Consultation Response from KC,
Ecology Unit

2026/91599 Wesley House, Huddersfield Road, Birstall, Batley, WF17 9AZ

Discharge of details reserved by conditions 3 (roof light), 8 (bin store), 9 (lighting), 10 (bat box), 11 (Construction Management Plan - Gravestone) on previous permission 2024/92105 for alterations to convert former offices to 21 apartments (Listed Building within a Conservation Area)

Date Responded: 07/08/2026

**Planning Approval Ref :** 2024/62/92105/E  
**Condition 9 – External Lighting**

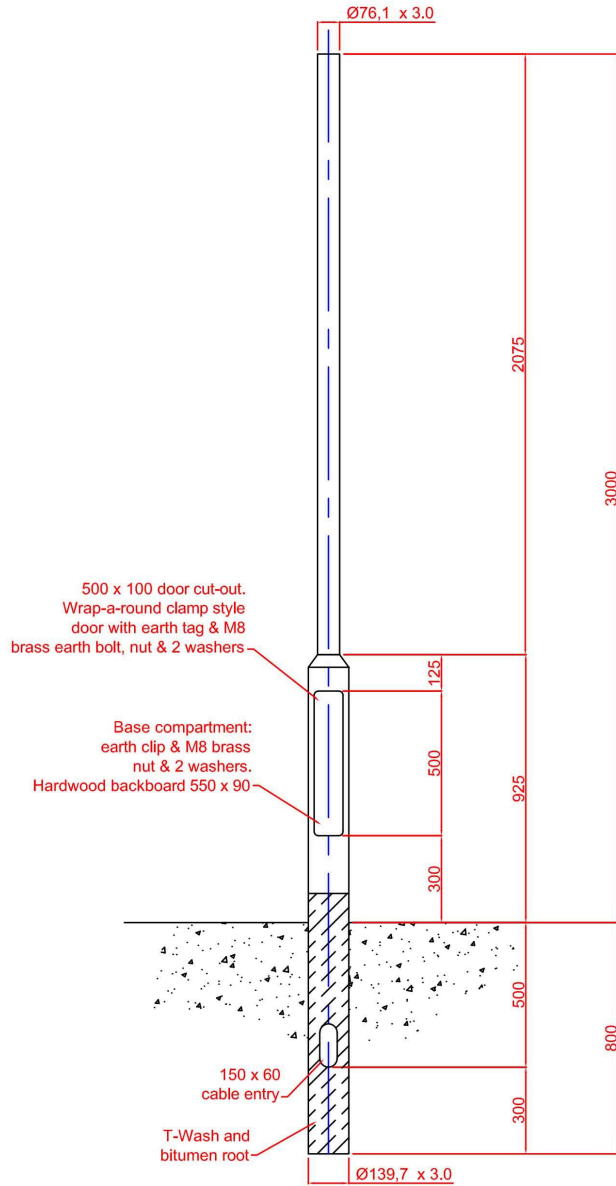
The submitted information details that downlighting will be installed on the building, and the locations of this lighting. The plans show the lighting will be on a motion sensor, and the proposed bat box location will not be illuminated. This condition can be discharged.
